RE: Response to Request for Information for South Eveleigh Locomotive Workshops (SSD-8517)

Ethos Urban has prepared this letter on behalf of Mirvac in response to the Department of Planning, Industry and Environment's (the Department) request for information (RFI) letter dated 12 May 2021 and the associated agency submissions received from the NSW Heritage Division and City of Sydney Council following the exhibition of MOD 9 for SSD-8517. This modification relates to the installation of three extraction hoods, fans and flues for three of the existing heritage coke furnaces in the Blacksmith workshop (Bays 1 and 2) of the Locomotive Workshops, South Eveleigh.

This RFI response letter addresses the items raised by the Department in the RFI letter and the agency comments. The response is accompanied by an updated East Elevation Plan at **Attachment A**.

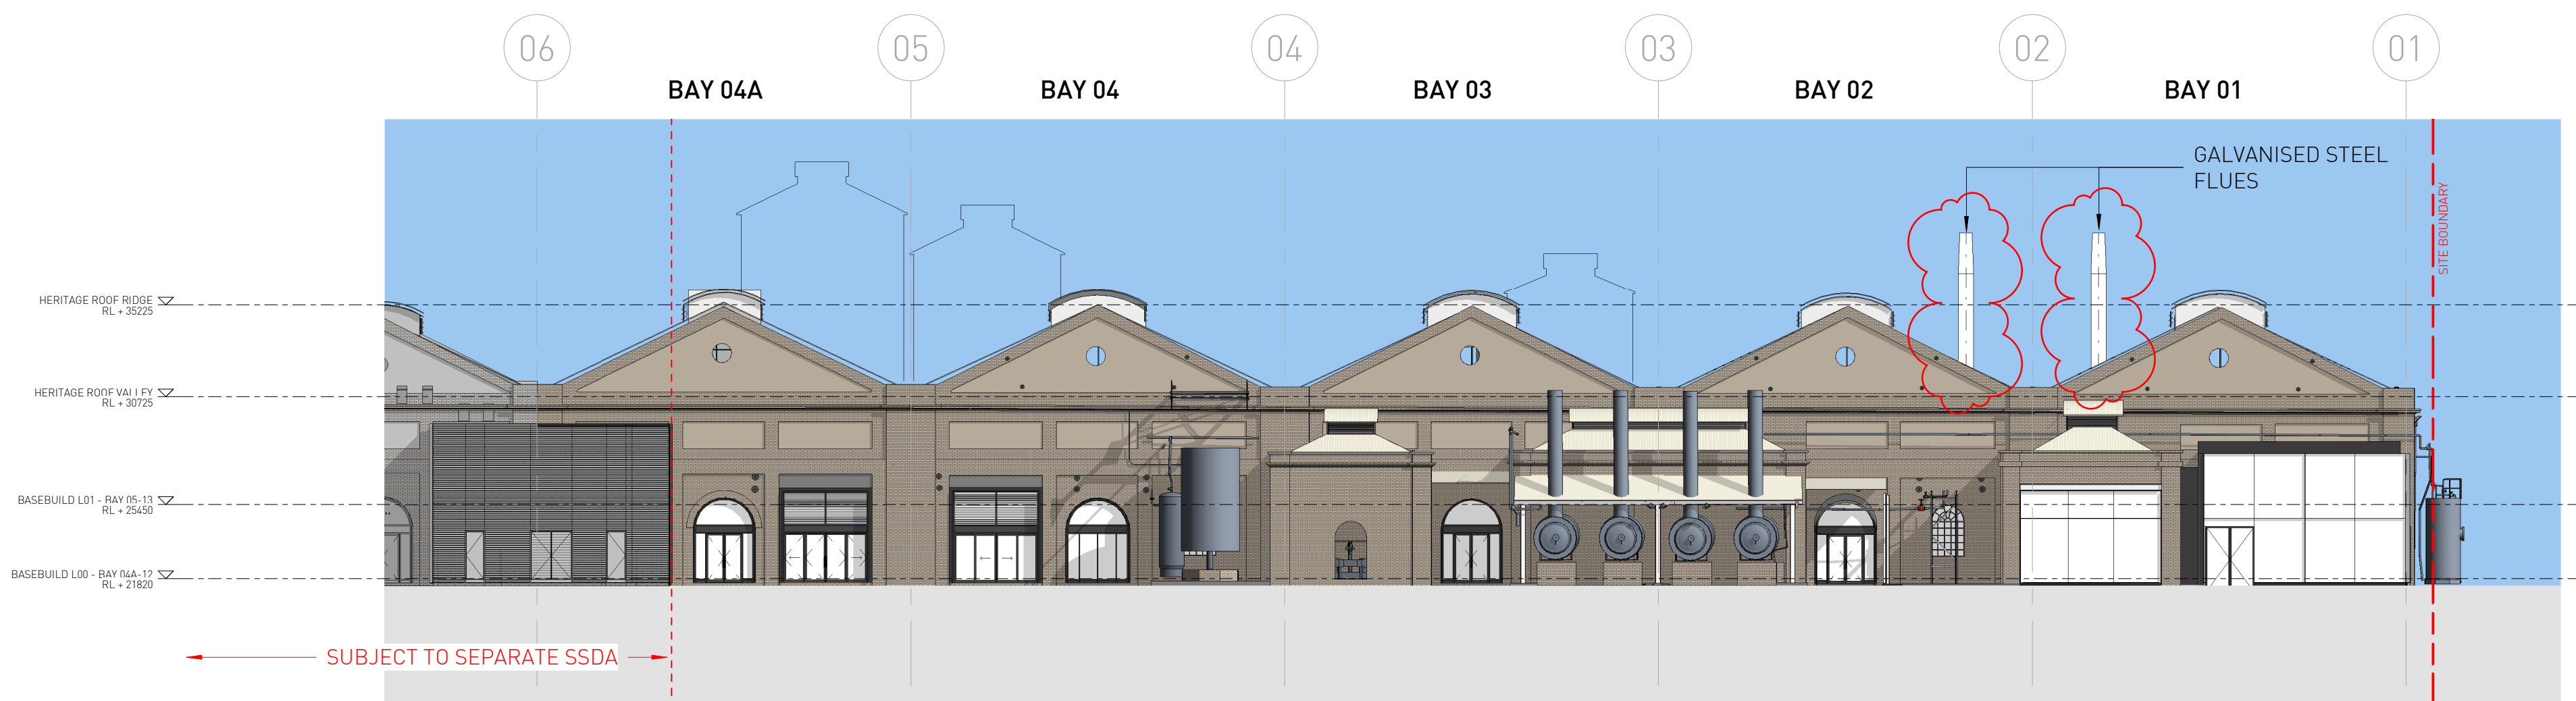
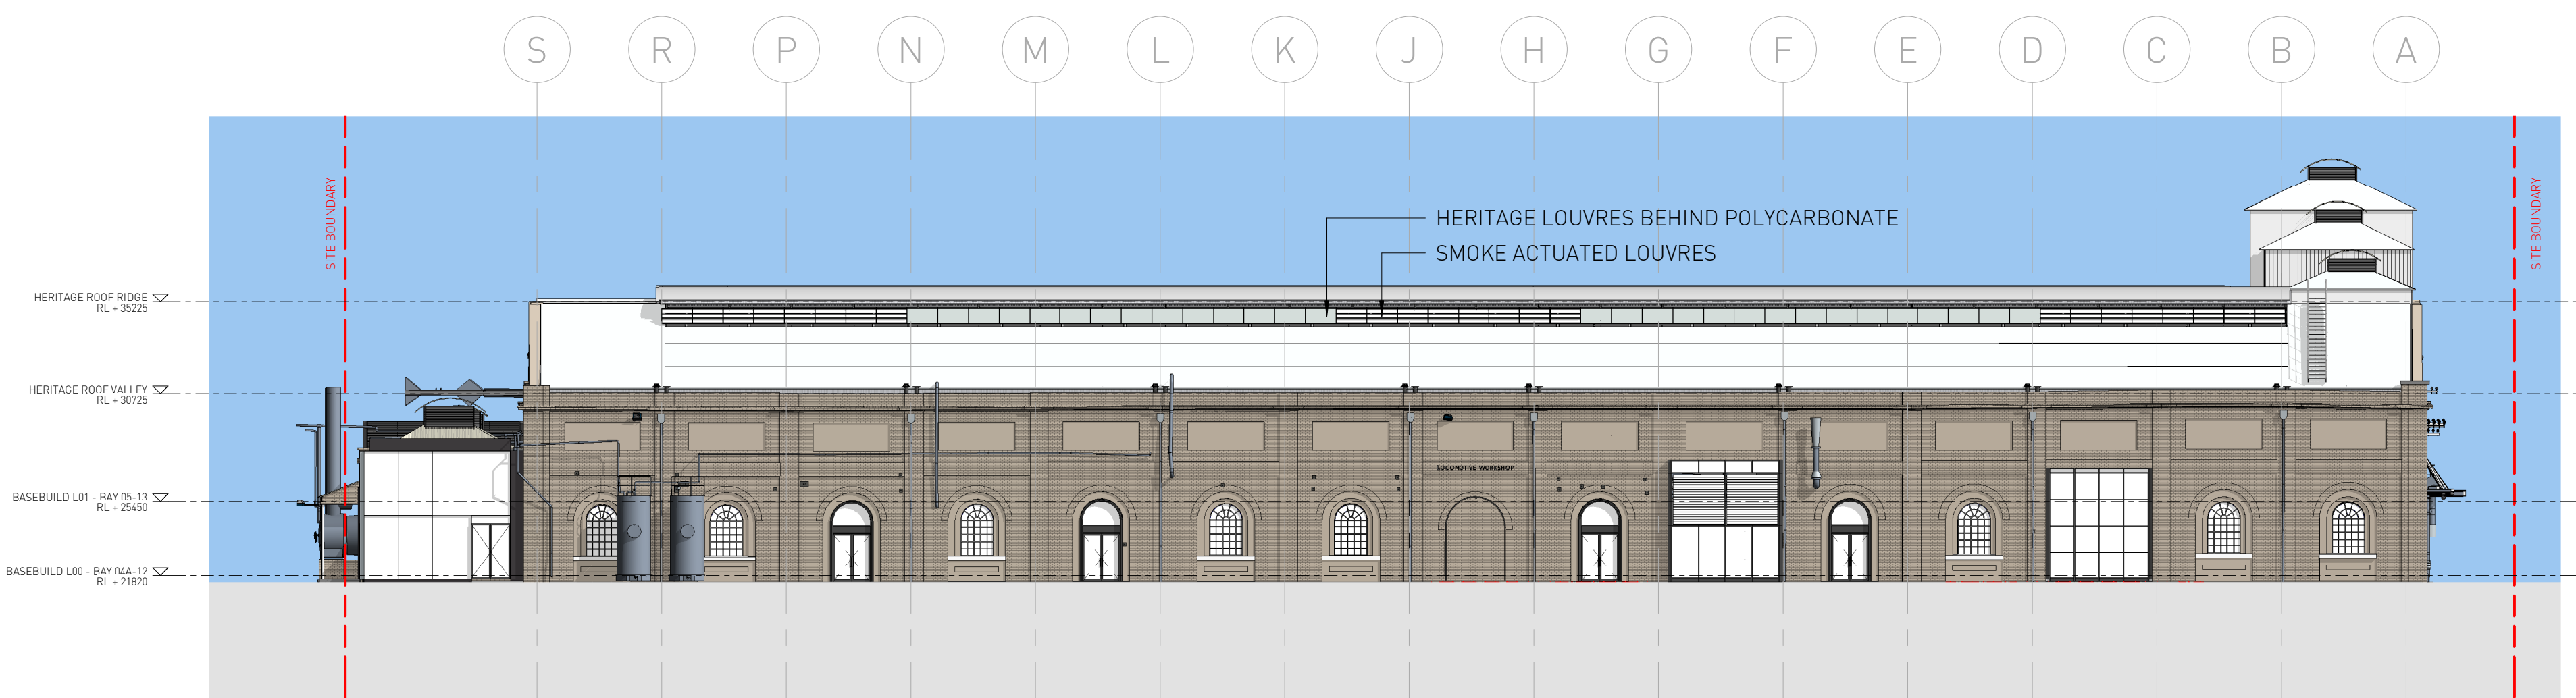
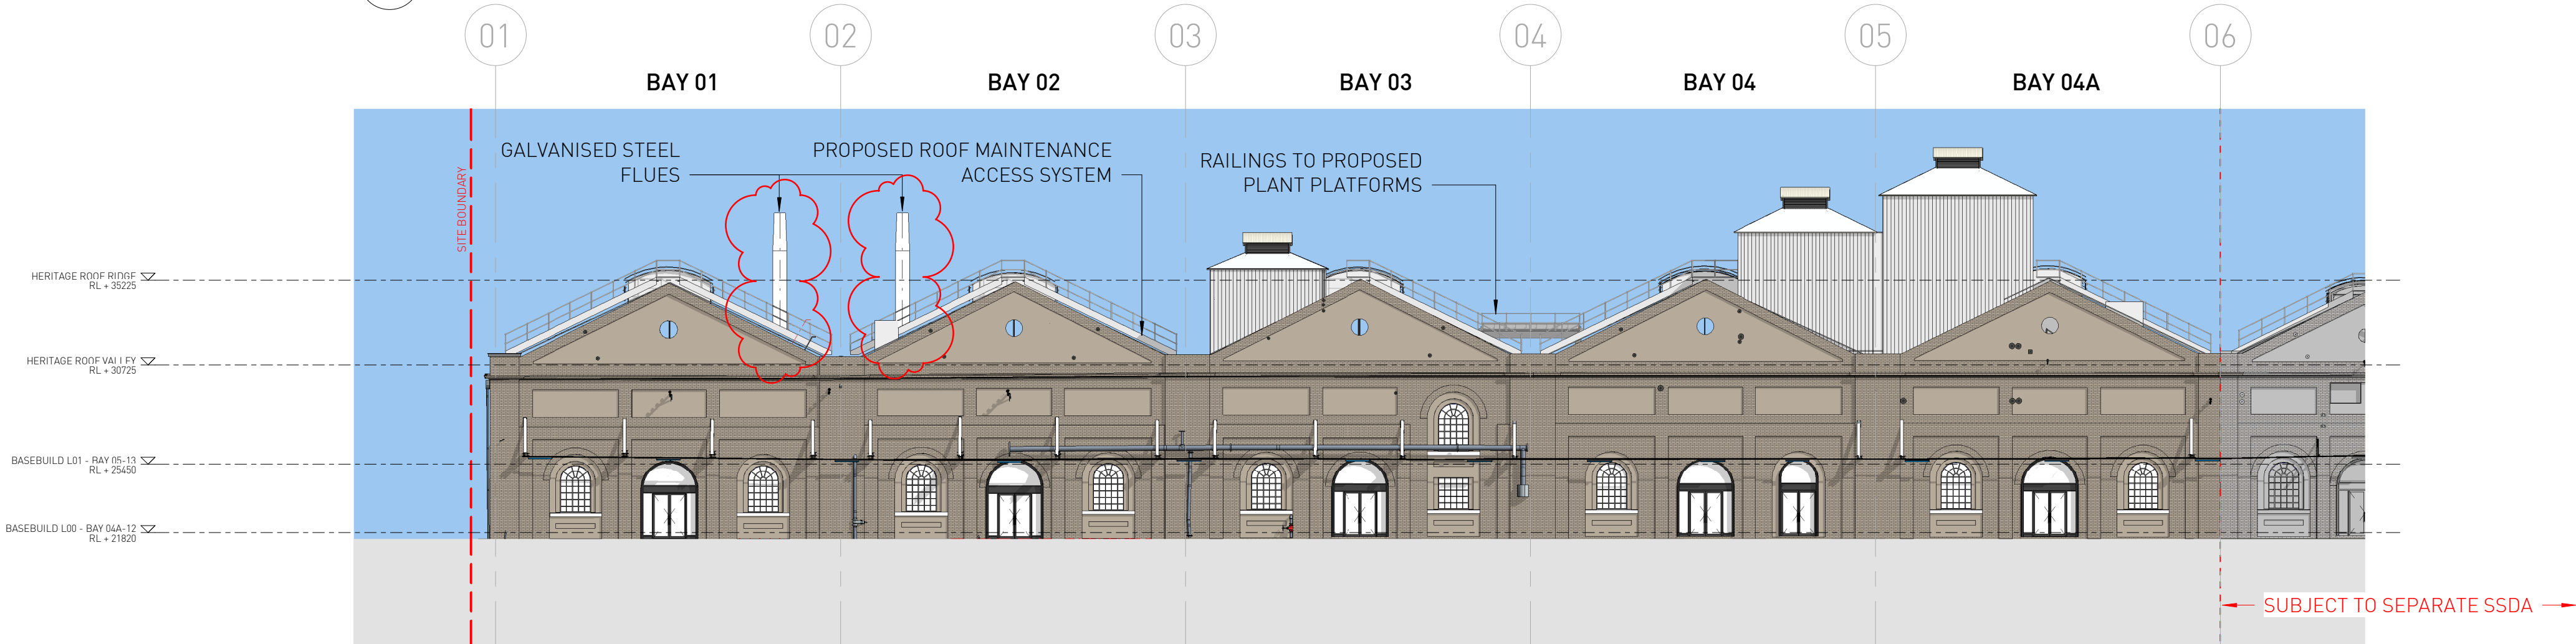
Comment	Response
Department of Planning, Industry and Environment	
The Department requests you provide an updated elevation drawing SA-AR-DWG-BB-B4-0340 to show the proposed flues from the eastern elevation of Bays 1-4a.	This is provided at Attachment A .
City of Sydney	
The City of Sydney raises no objections to the proposal.	Noted.
From a heritage perspective the proposed flues have galvanised steel finish and appear to be supported from the existing trusses by cables. This is all considered reversible and can be supported as they fit in with the industrial context of the site.	Noted.
In regard to the air quality impacts, however, the following items require further review by the Department of Planning, Industry and Environment (DPIE): The Mechanical Ventilation design which is claimed to be more efficient at capturing direct exhaust emissions and smoke generated during furnace and oil quenching operations, to ensure future staff are protected. All mechanical ventilation should be compliant with AS1668 and signed off by a competent person (e.g. mechanical engineer or similar) prior to the issue of a Construction Certificate.	Noted. This is supported as an appropriate condition of consent.
